Application Reference: Y/9/25/DOC Site Name: Fleurie Nursery Lake Lane Barnham PO22 0AL	Initial Issue Date: 21/02/2025 Issue Date: Reviewer Reference: ADC/SB
--	---

Summary and Recommendation:

Condition 4: **Objection**
Condition 5: **Objection**
Condition 6: **Objection**

DRAWN	KCK	ENGINEER	TZ	CHECKED	CS	APPROVED	CS
DATE	DECEMBER 2023	SCALE @ A1	1:200				
JOB No.	C2904	STATUS	P	DRAWING No.	101	REV.	P4

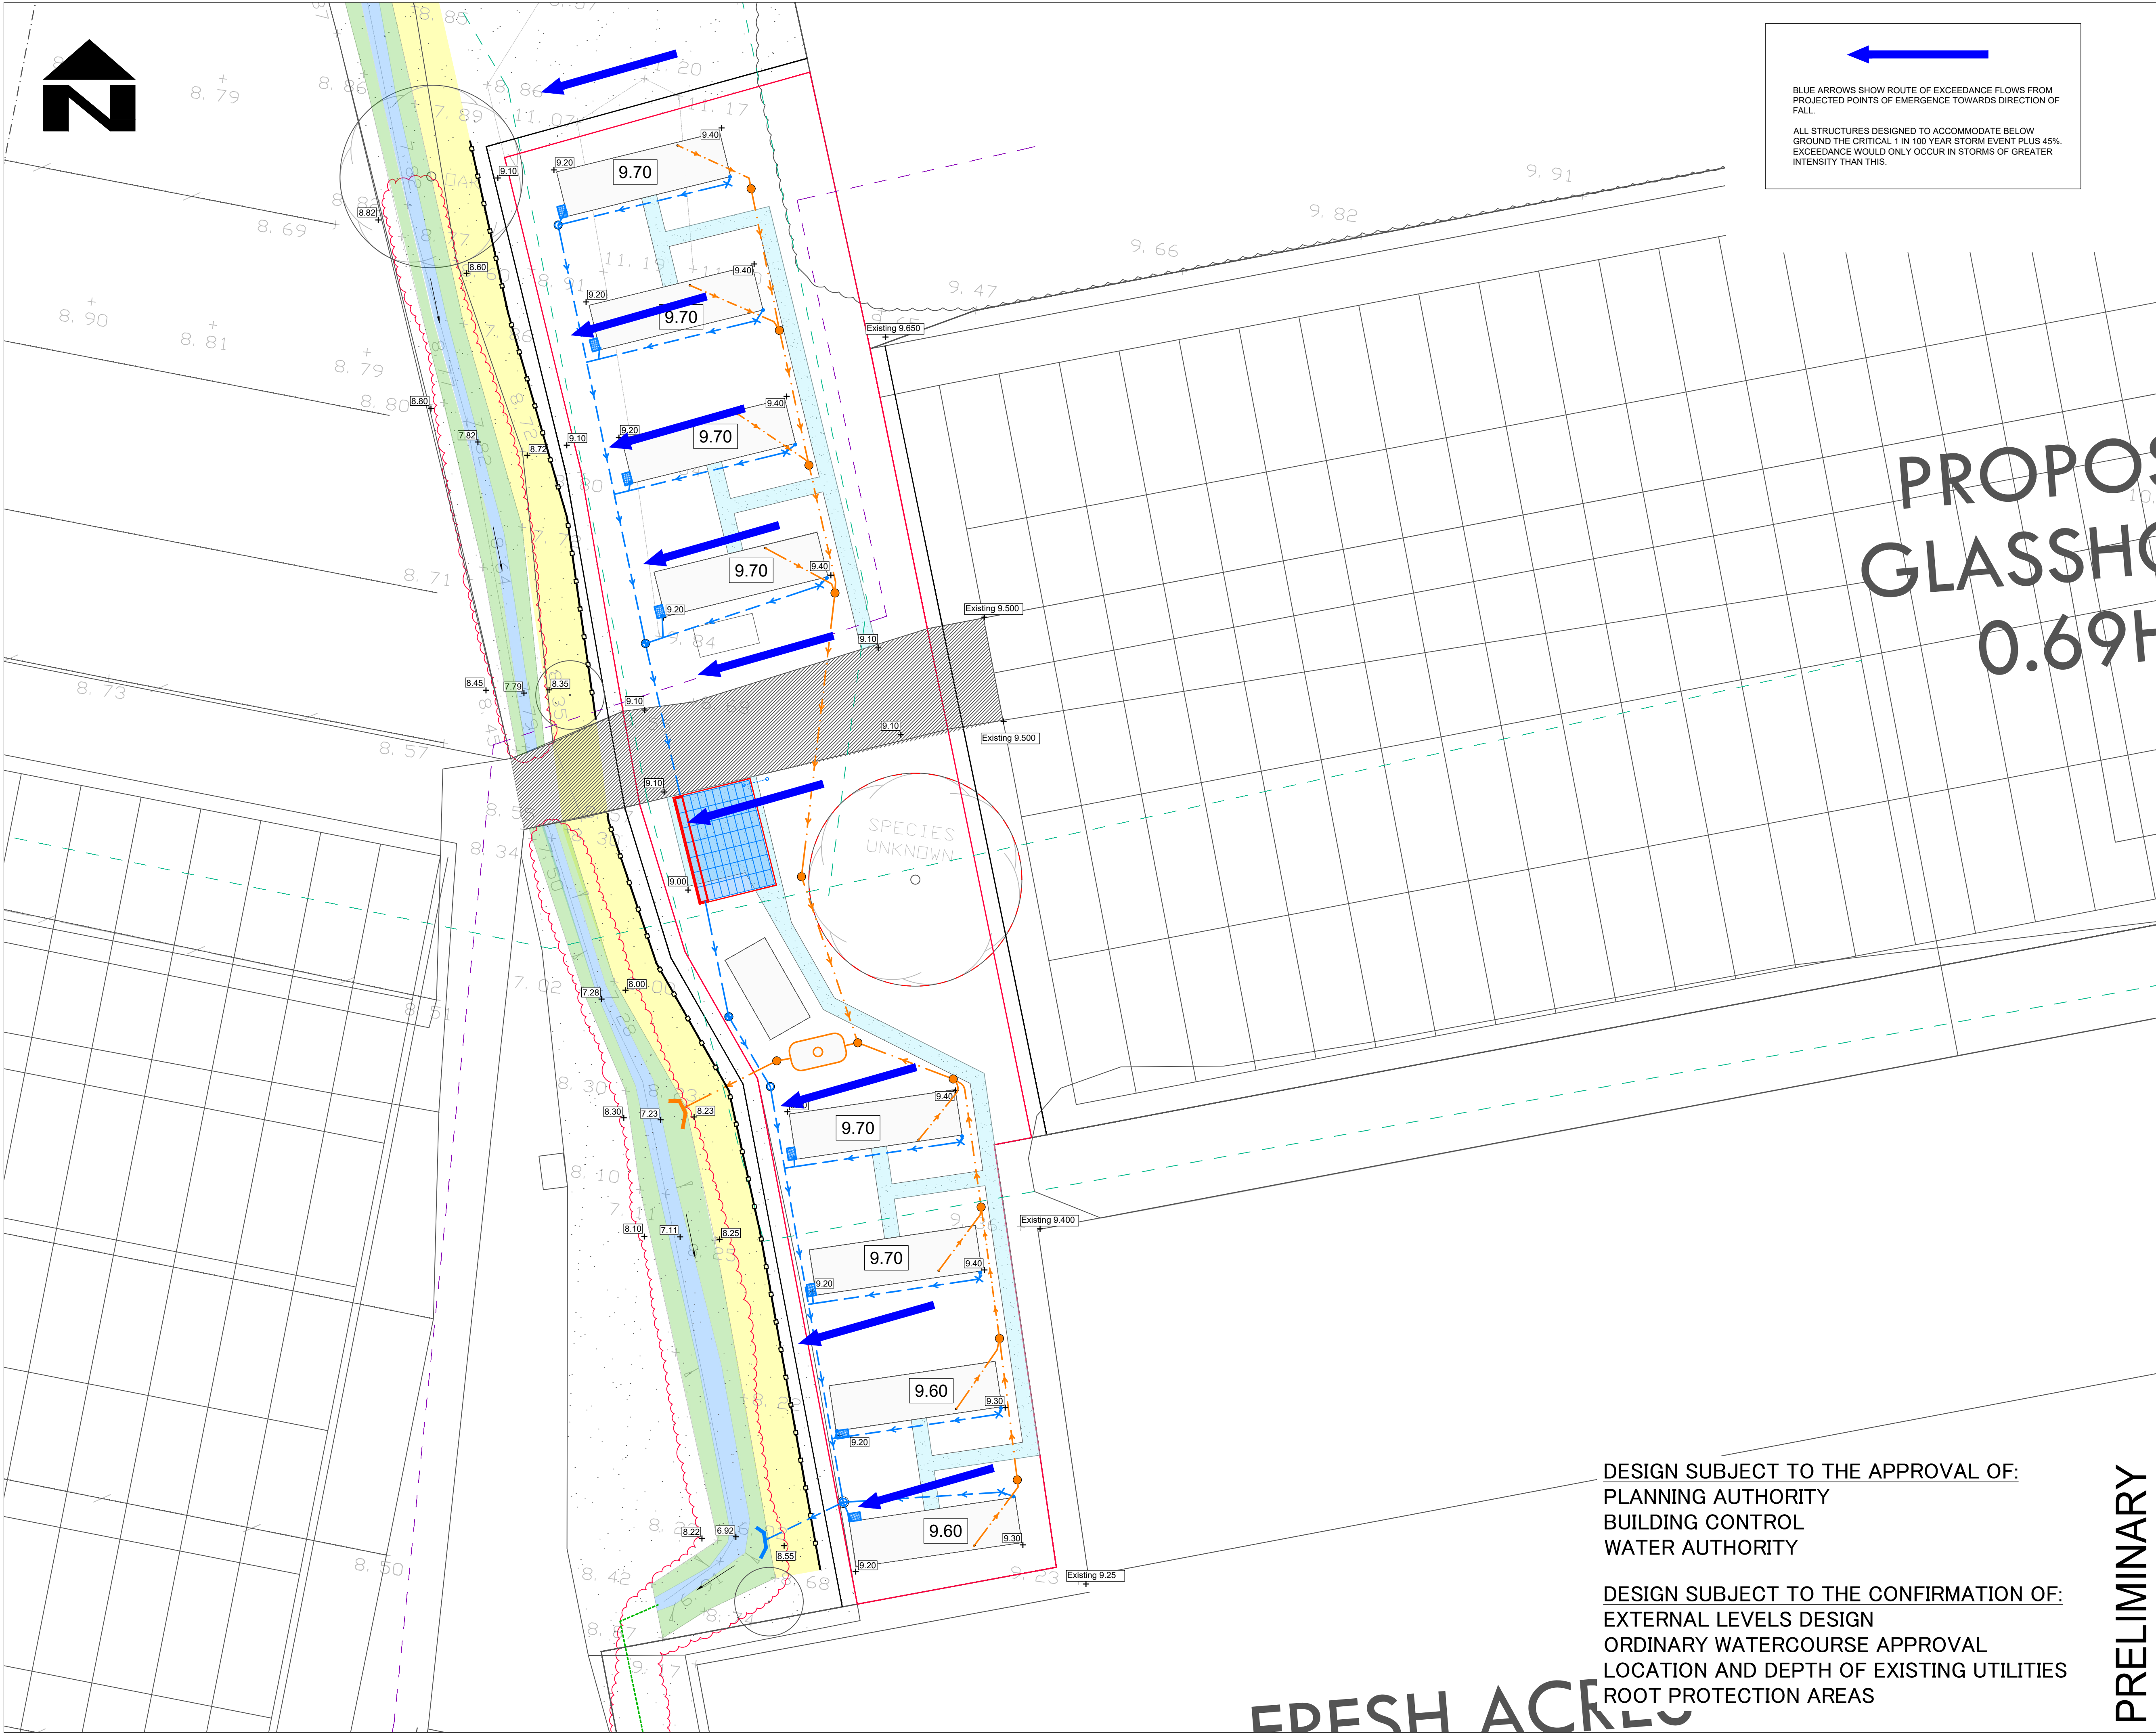
4.	Please correct discrepancies between cover and invert levels on the plans and the calculations. [It is acknowledged that this is unlikely to affect the design.]	Discrepancies are now updated, please find the revised drainage plan and drainage calculations attached.

6.	Please show any relevant easements on the plans.	The existing watercourse 3m easement is now indicated on drainage plan

9.	The landscape and ecology management plan refers to a post and rail fence installed post-development to protect the rife. Please clearly demark this fence on the plans and ensure that is not within the easement for the watercourse.	The proposed post and rail fence is now indicated on the proposed drainage plan. Proposed fence is to be located min. 3m away from the top of the banking (easement).

11.	The orifice for S5 is described on the layout as being 500mm diameter. This is assumed to be a typo (confused with the chamber diameter), please correct.	Orifice chamber diameter has been updated to 600mm diameter and orifice diameter to 20mm.

16.	There is a risk of a clash between the surface water and foul drainage north of S4 and west of F6. Please adjust the design, if possible, to minimise this risk.	Clash has been reviewed and a separate note indicating proposed SW and FW pipes invert levels is now indicated.

Sel Controflow 600-900Ø Orifice Chamber

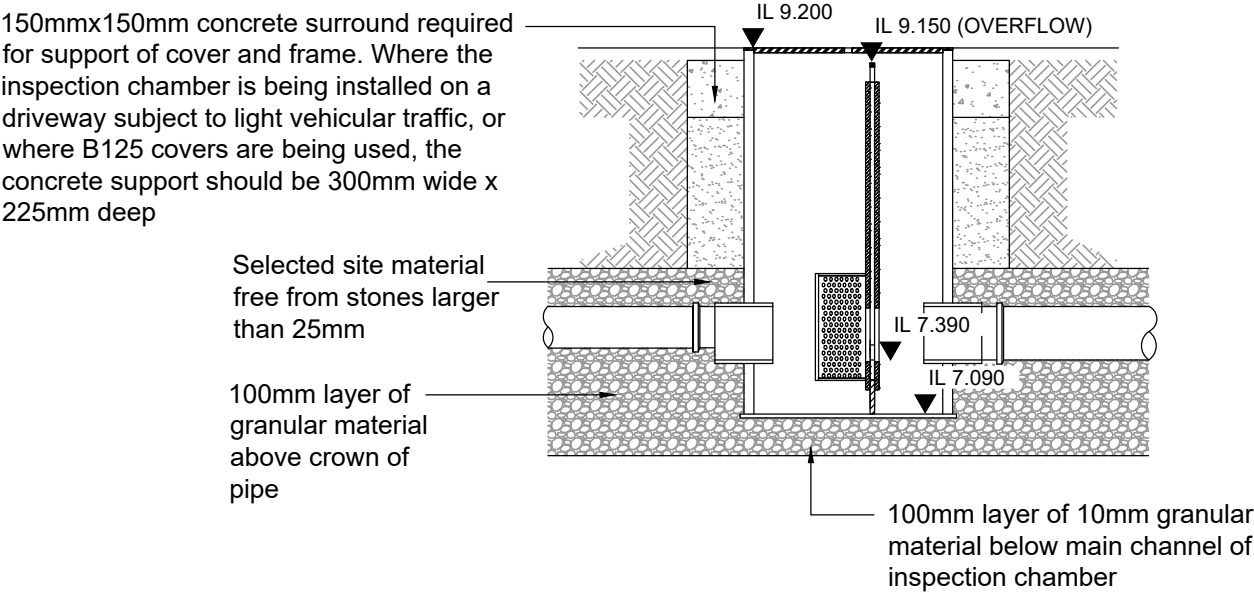
14.	Please detail the overflow level of the Sel Controflow 500 Orifice Chamber.	Overflow level is now indicated on orifice chamber detail.			
15.	The orifice for the design is very small, how is risk of blockage mitigated for in the design?	All downpipes are to be installed with Leaf separators. Orifice chamber is to be installed with orifice filter plate.
